High Country Rural Planning Organization (RPO)
Municipalities and Counties of
Brushy, Ashe, Avery, Mitchell, Watauga, Wilkes, and Yancey

December 20, 2010

Subject: B-4676, Replacement of Bridge No. 29 on SR 1001 (Oakwoods Rd) over Cub Creek in Wilkes County

PROJECT REFERENCE NO. B-4676		SHEET NO. 4	
RW SHEET NO.			
ROADWAY DESIGN ENGINEER	HYDRAULICS ENGINEER		
INCOMPLETE PLANS DO NOT USE FOR R/W ACQUISITION PRELIMINARY PLANS DO NOT USE FOR CONSTRUCTION

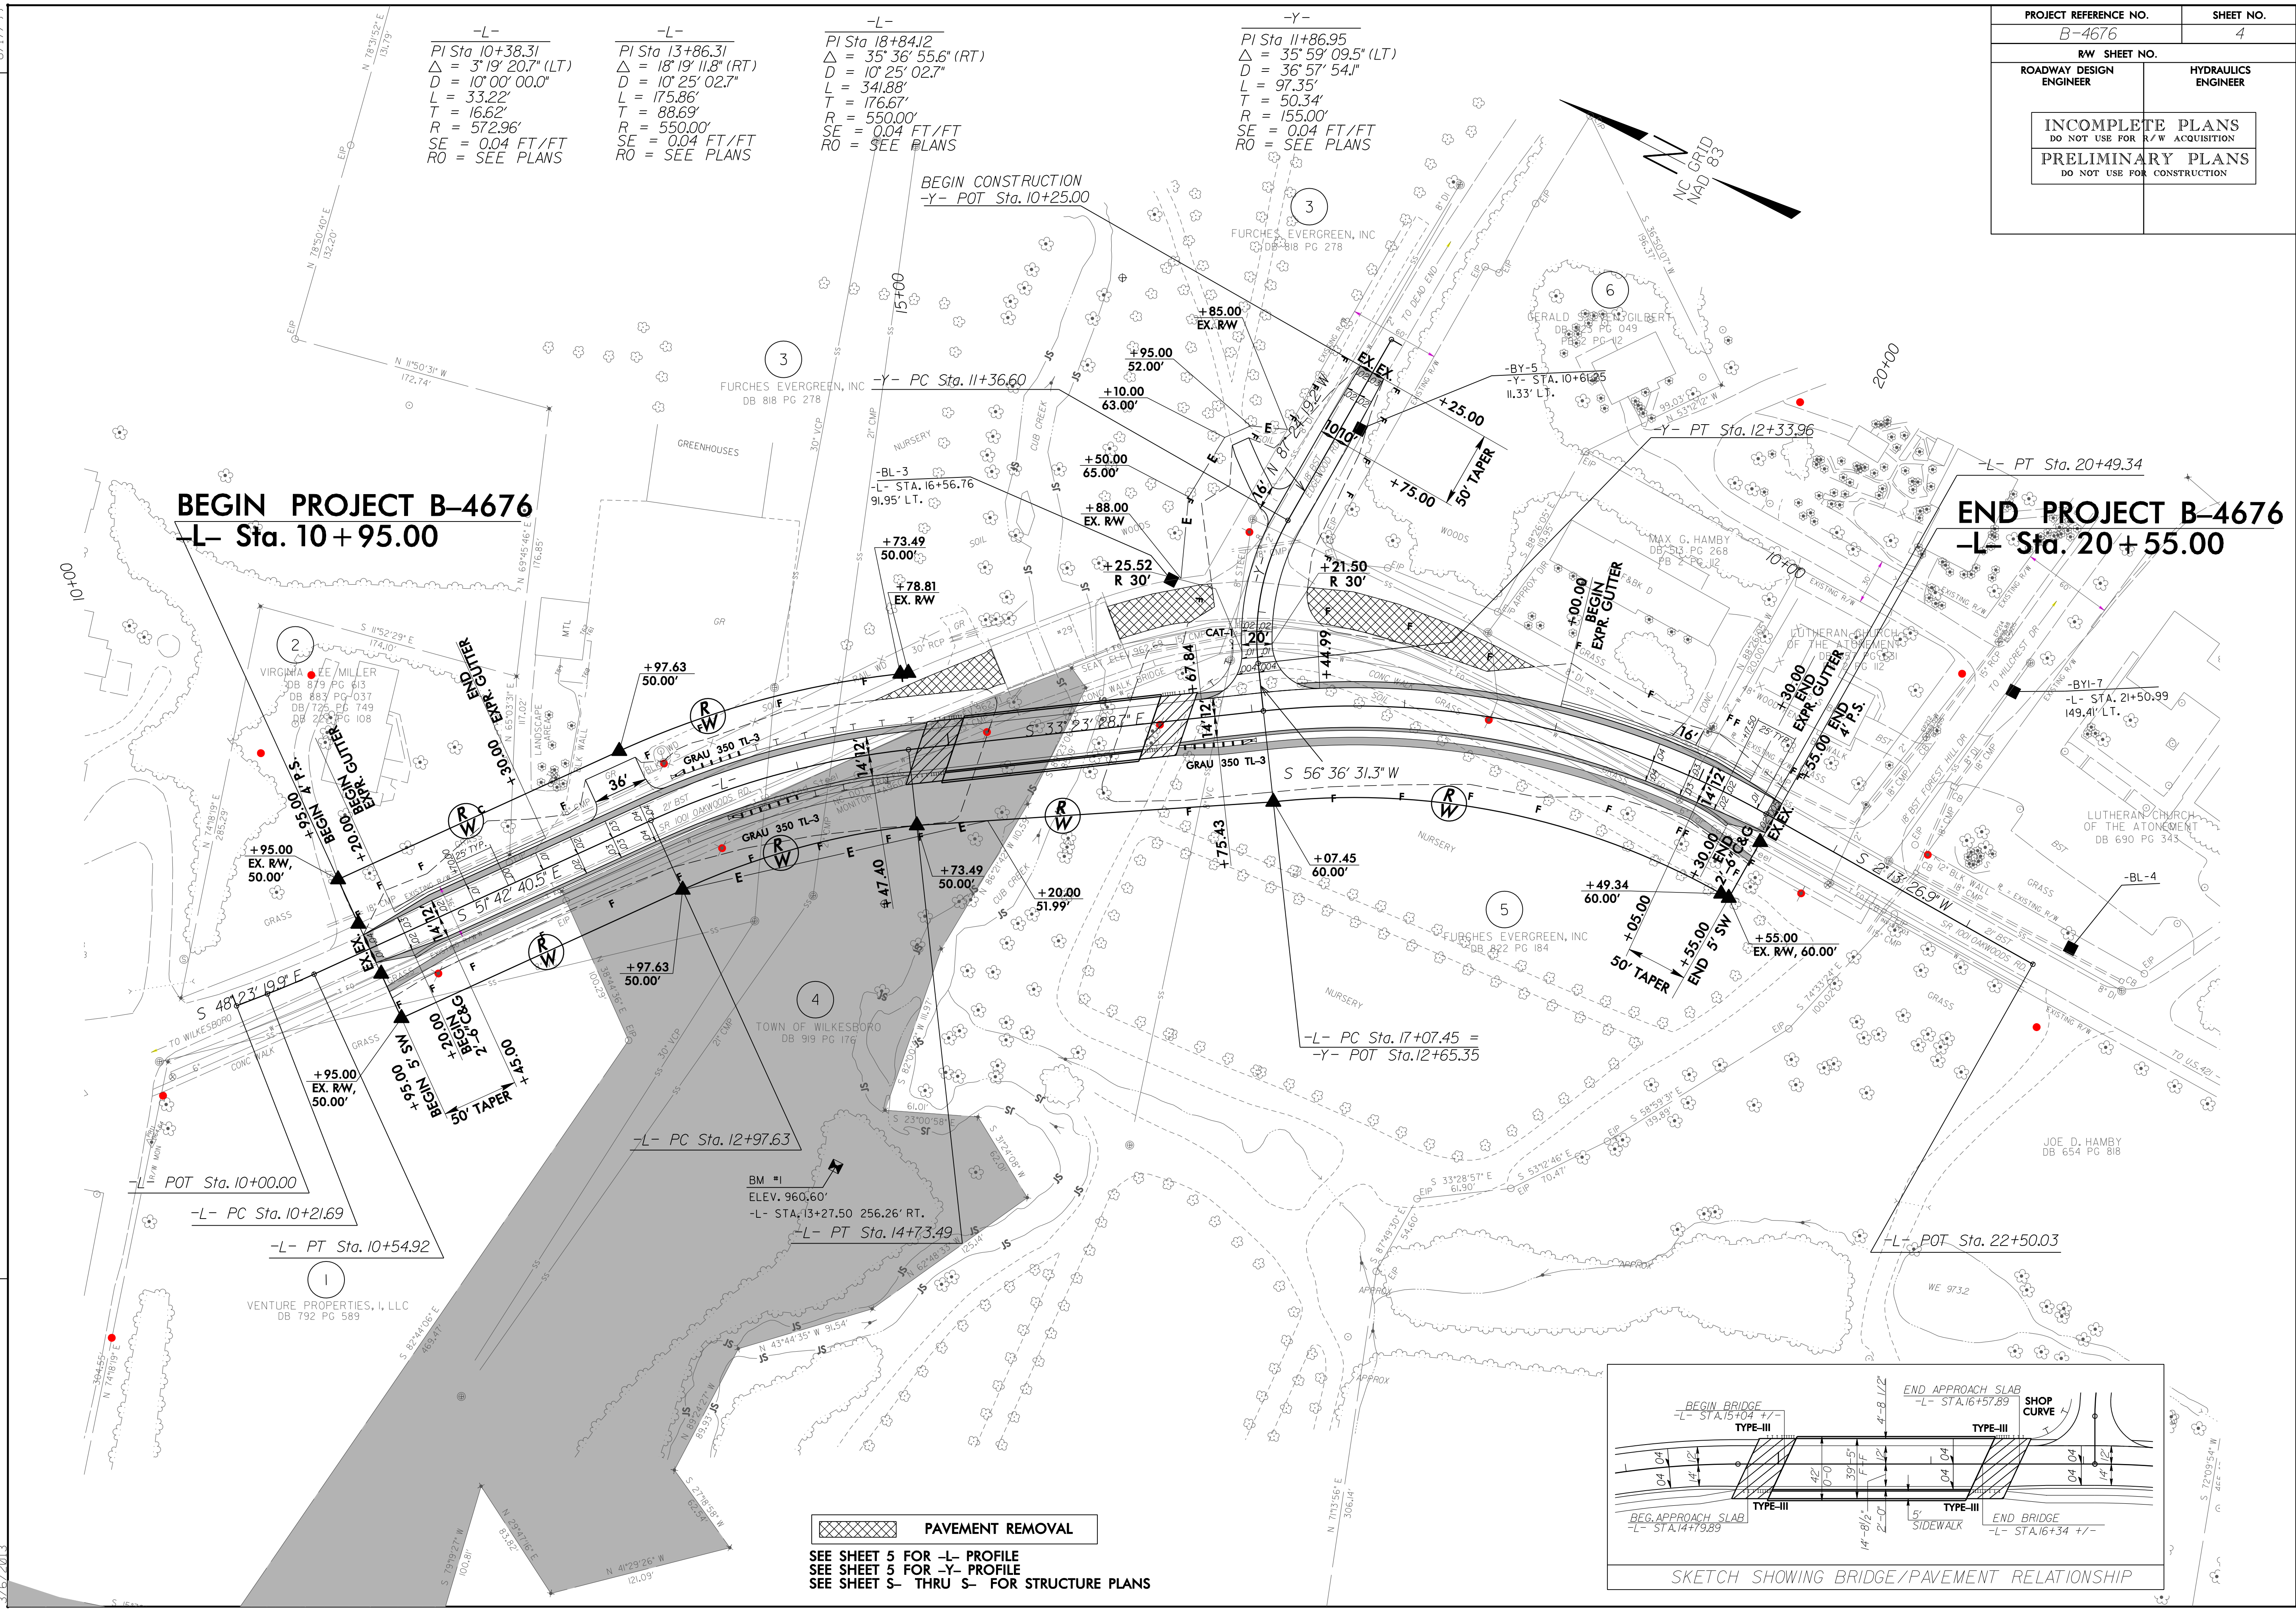
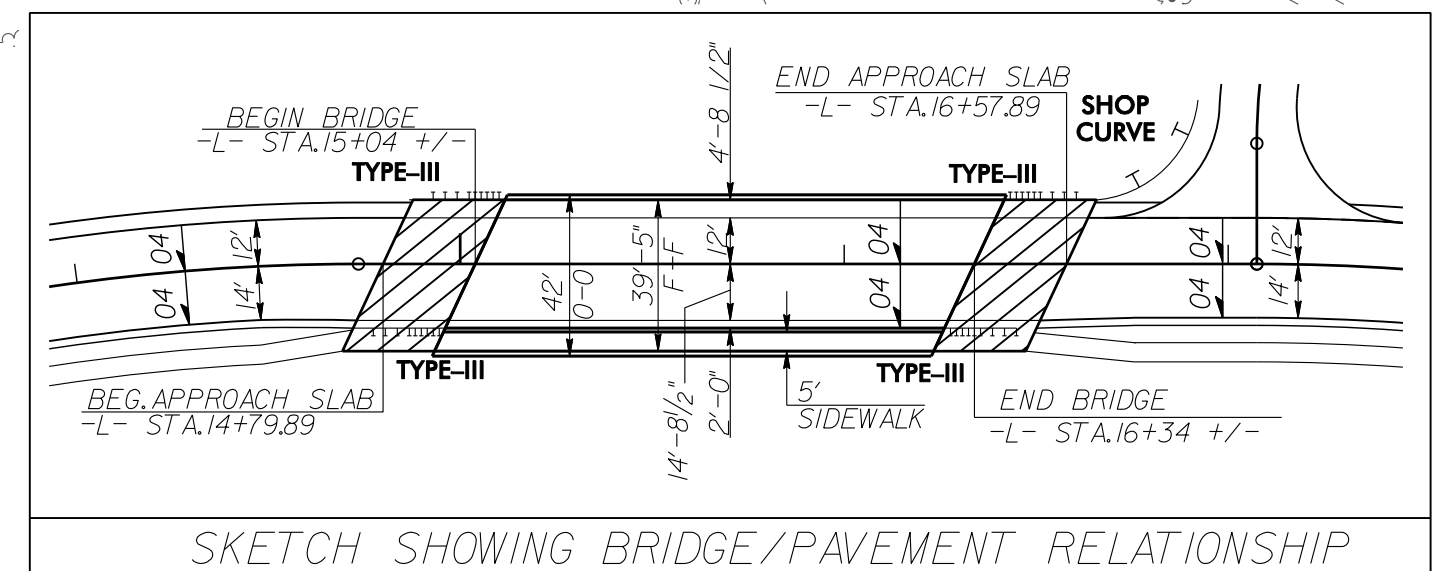
- Pedestrian access should be maintained across Cub Creek. FS-0711B recommended sidewalks on both sides of Oak Woods Road from its intersection with Main St and NC 18 to the intersection with US 421.

- The bridge should be wide enough to allow bicycle lanes. (Oakwoods Rd. is part of the Brushy Mountain Road Bicycle Route identified on the Wilkes County Bicycle Route Map. Cyclists frequently start at the historic courthouse and travel south along Oakwoods Rd./Brushy Mountain Rd. over the Brushy Mountains to Alexander County and back. The ride provides spectacular views of the Yadkin Valley and access to many apple orchards.)

- Separation of pedestrians from vehicles is important to the Town of Wilkesboro and the additional pavement width provided by a bike lane would assist in providing this buffer zone if sidewalks are provided on the bridge. The Town would like to try and maintain the current character of the walking trail in Cub Creek Park by keeping a pedestrian bridge separate from the roadway.

- The new bridge should provide an area for a multi-use trail to pass under the bridge along the creek to allow the connection of Cub Creek Park to Forest Hills Subdivision (located off of Oakwoods Rd.) and to future sections of the Yadkin River Greenway.

- Limit the impacts to a business that has recently located to the west of the existing bridge.
